**Reference TR010063 - Application by Gloucestershire County Council for an Order Granting Development Consent for the M5 Junction 10 Highway Improvements Scheme**

**Deadline 4 Submissions by Bloor Homes Limited and Persimmon Homes Limited (Interested Party Reference Numbers 20047701 and 20047702) (together the Interested Parties)**

WRITTEN POST HEARING SUBMISSIONS INCLUDING WRITTEN SUBMISSIONS OF ORAL CASES MADE AT THE ISSUE SPECIFIC HEARING 3 (ISH3) AND COMPULSORY ACQUISITION HEARING 1 (CAH1) W/C 12 AUGUST 2024

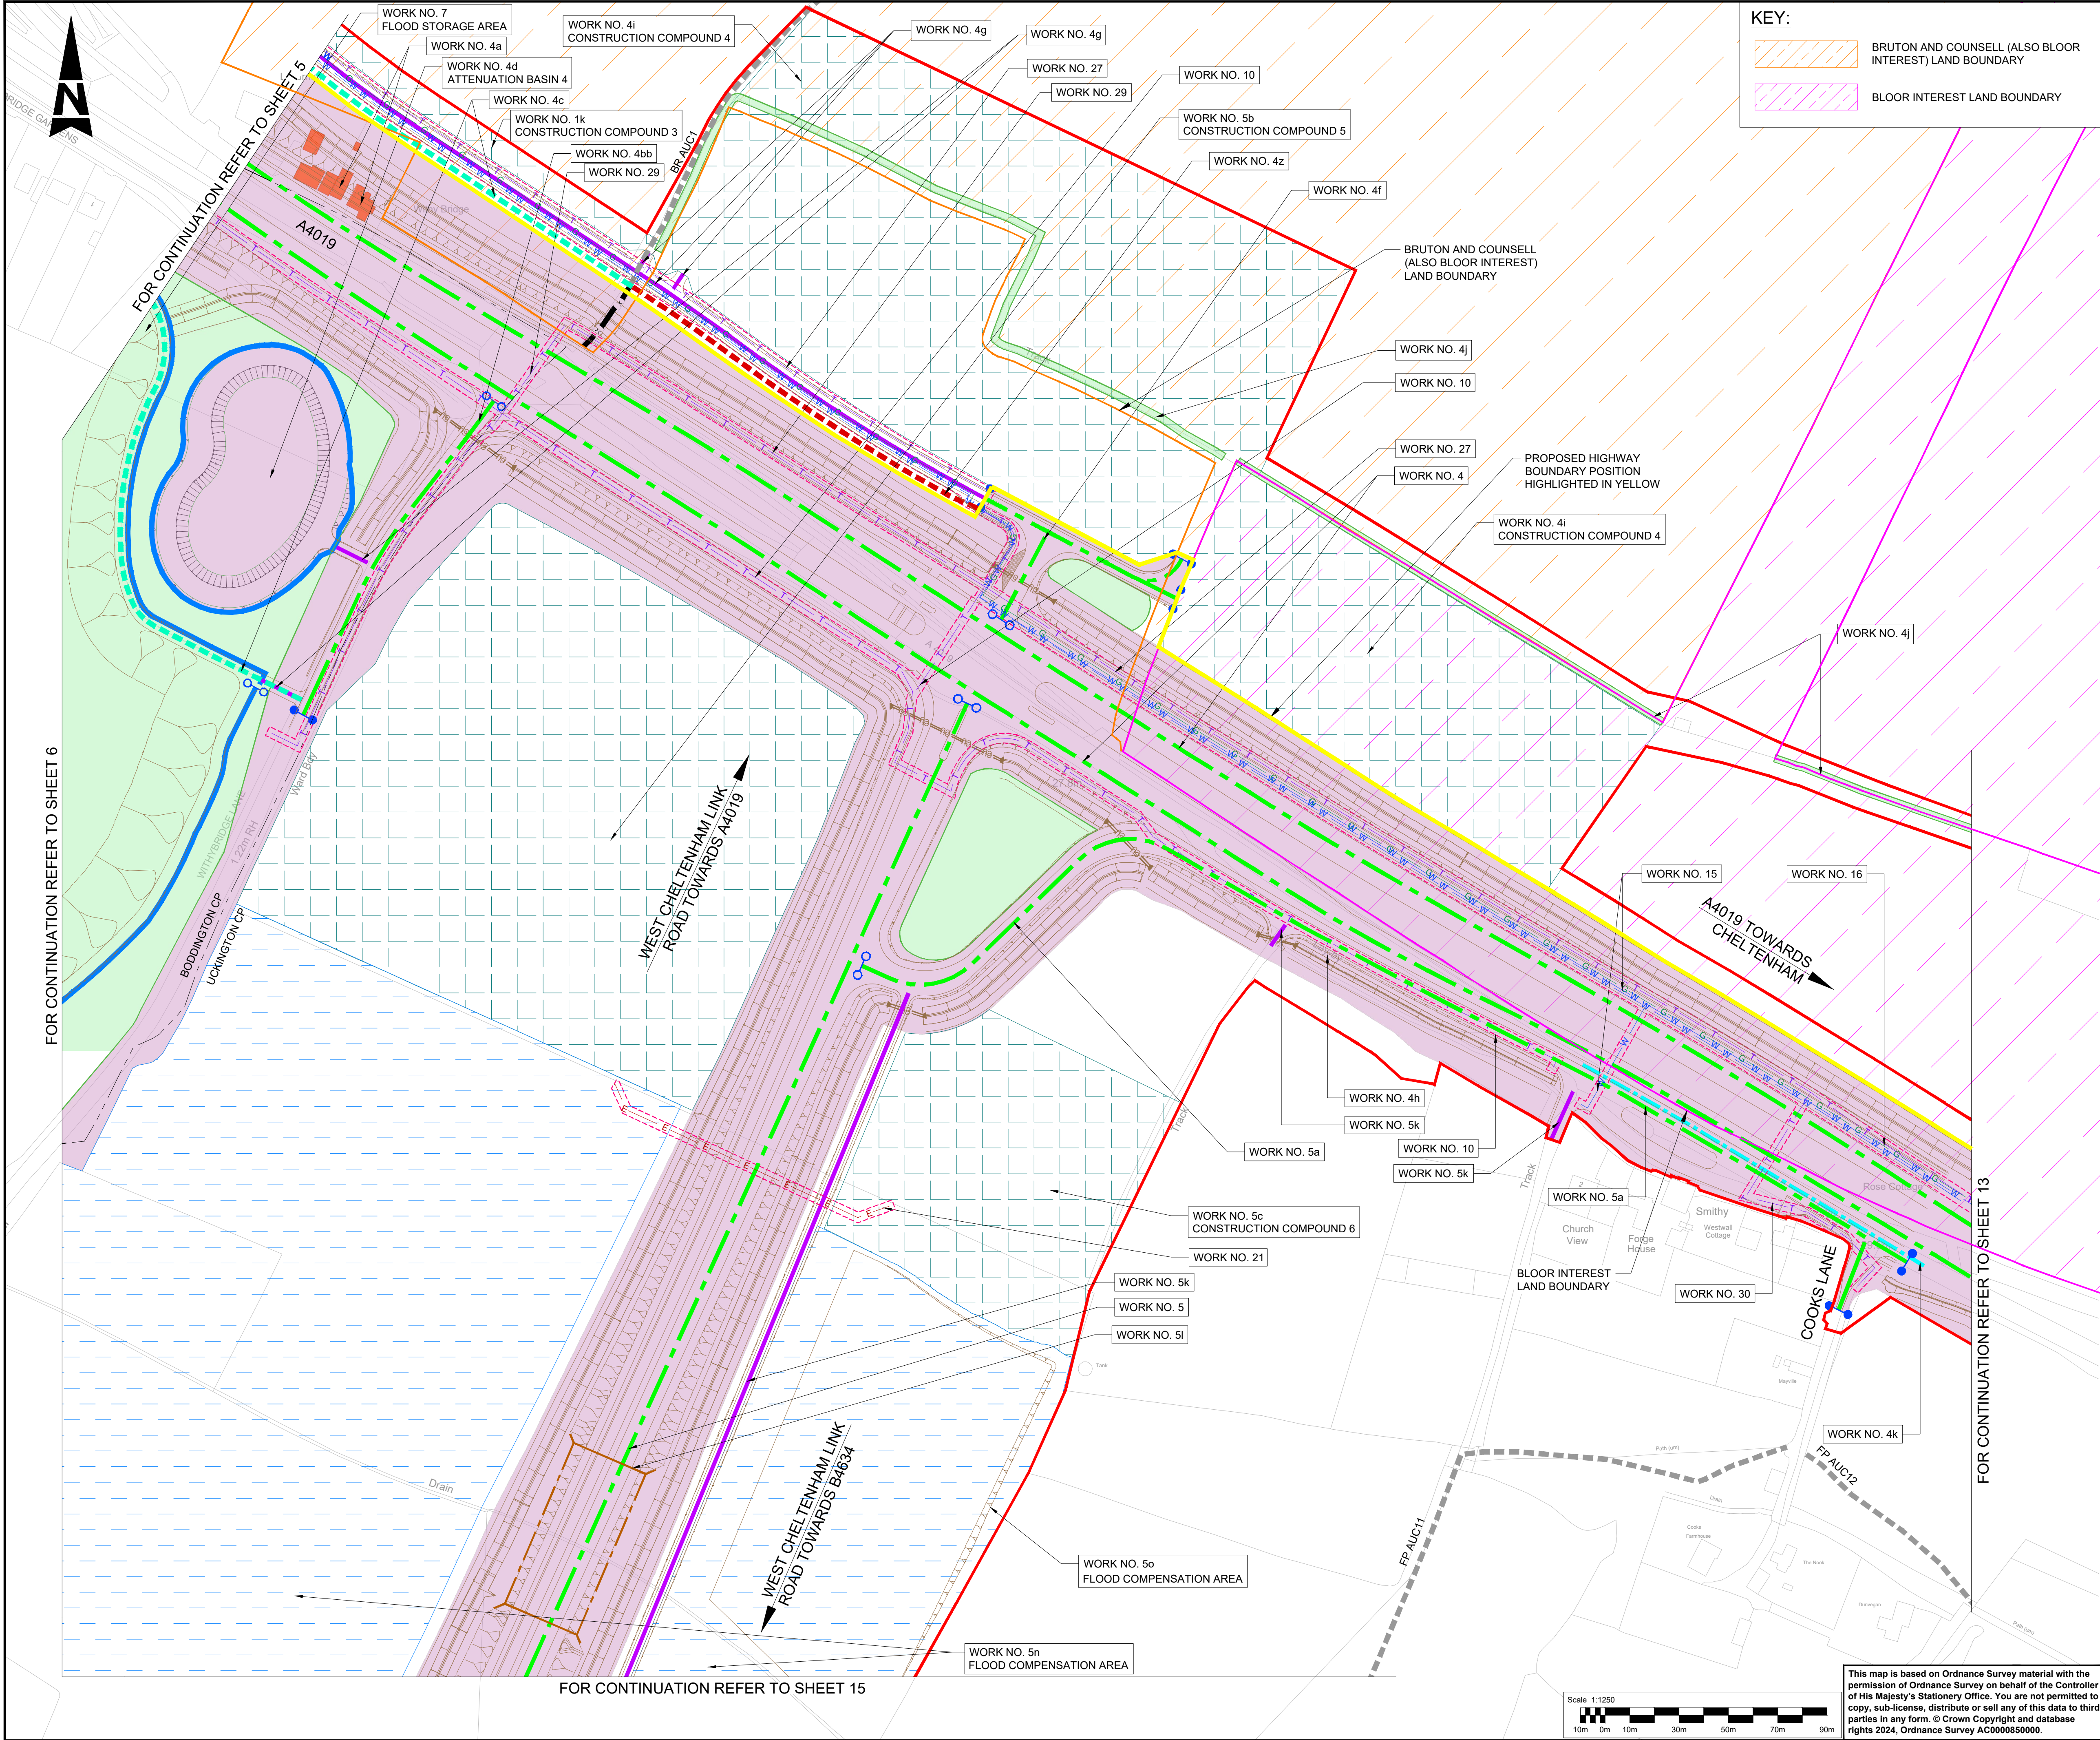
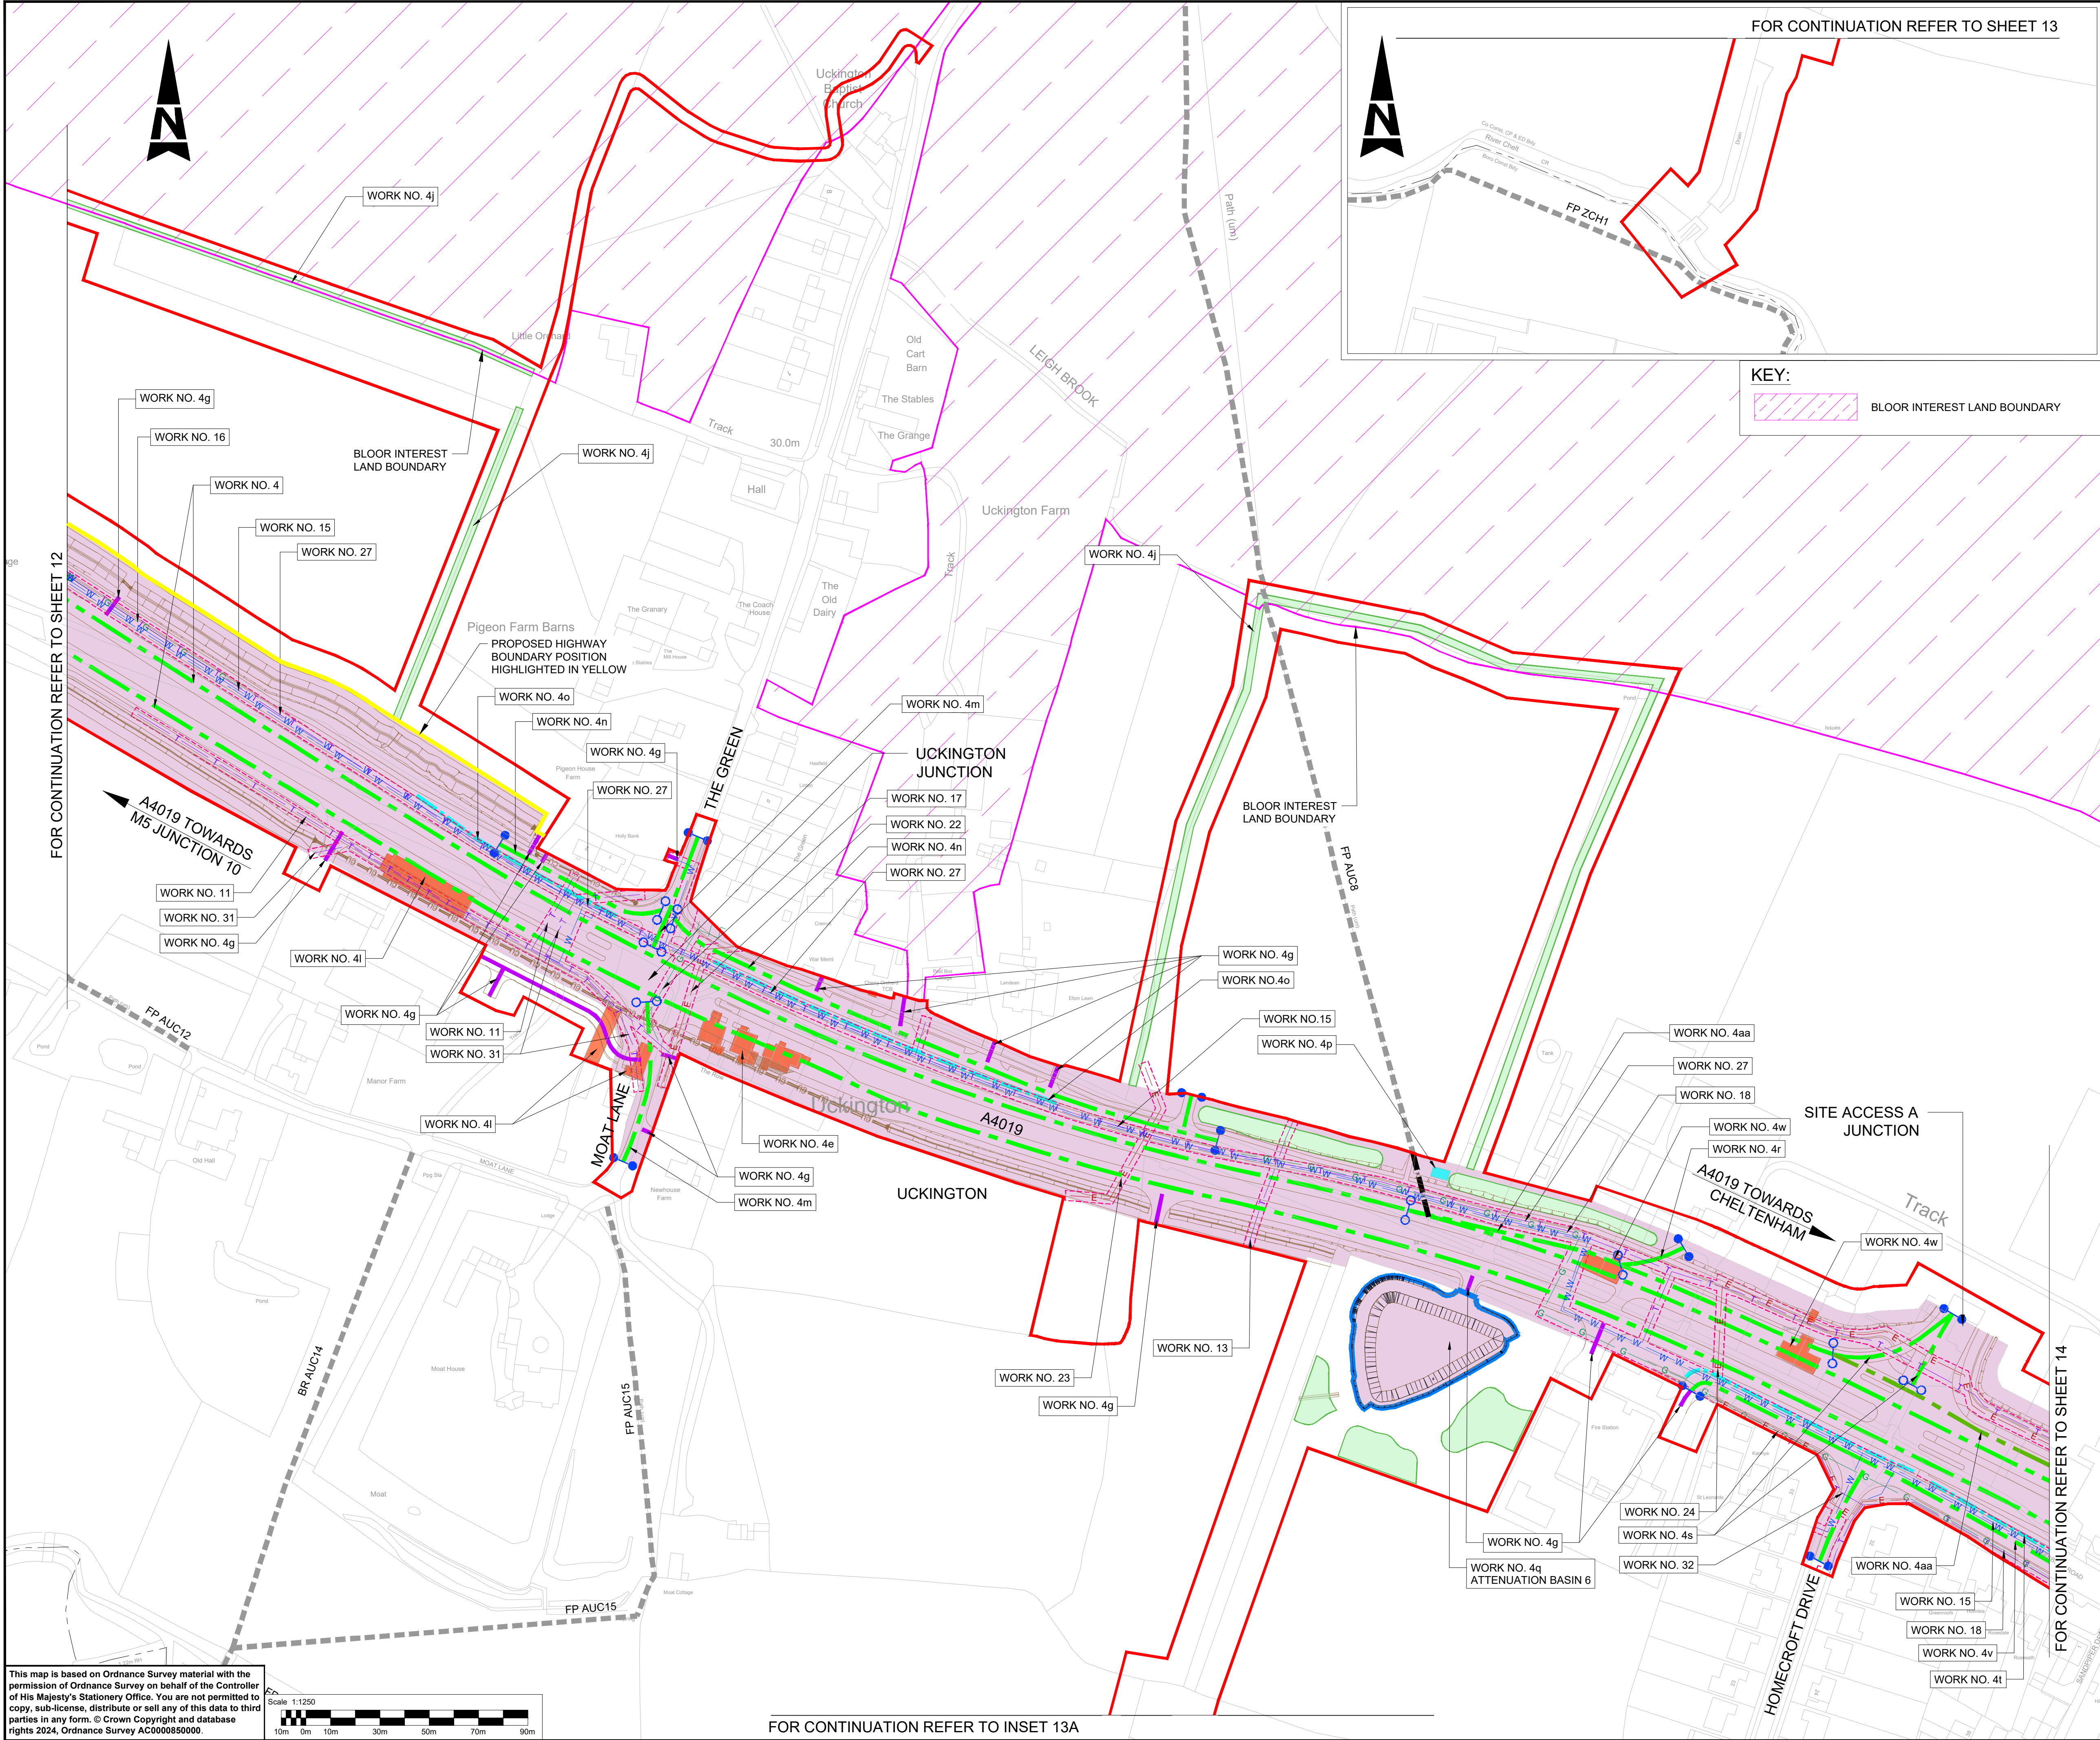
- 1.9 The Scheme would amalgamate Access A – G into a single signal controlled junction from the A4019 Tewkesbury Road. The single junction would split into eastern and western segments. The eastern segment would combine to replace Accesses E, F and G. The western segment would combine to replace accesses A, B, C and D, all of which are in regular use.

- 1.10 A vehicle tracking drawing has been provided by the Applicant of the combined farming access which highlights a vehicle track for a tractor and hay wagon with a length of 19m and width of 2.5m. However, this does not meet the landowner's access requirements for the following reasons:

- (a) Farm machinery is wider than the design vehicle used and is typically in excess of 3m wide (noting also that vehicle sizes are increasing as indicated above).

- (b) At peak times the combined access track will be frequently used – each landowner may have 4 – 5 tractor rigs towing machinery in order to ensure constant take off from a combine harvester.

- 1.11 Inevitably therefore at certain times there would be conflicts between multiple oncoming vehicles in this area. It has not been shown that two vehicles towing machinery exceeding 3m width could pass within the access road. This could then result in conflicts within the signalised junction arrangement and in particular vehicles being 'stuck' within the junction.

- 1.12 It is the landowner's view that access to its land should be provided via a direct north-south road from the junction, as opposed to the current arrangement which provides a tight corner radius which will cause operational and safety issues at peak times.

- 1.13 This is a genuinely held view from a farm operations perspective. Although the existing access gates are simple, each landowner is able to access its land independently. With the Scheme as proposed, this will be shared via a narrow track, and there is a risk of conflict between oncoming large machinery.
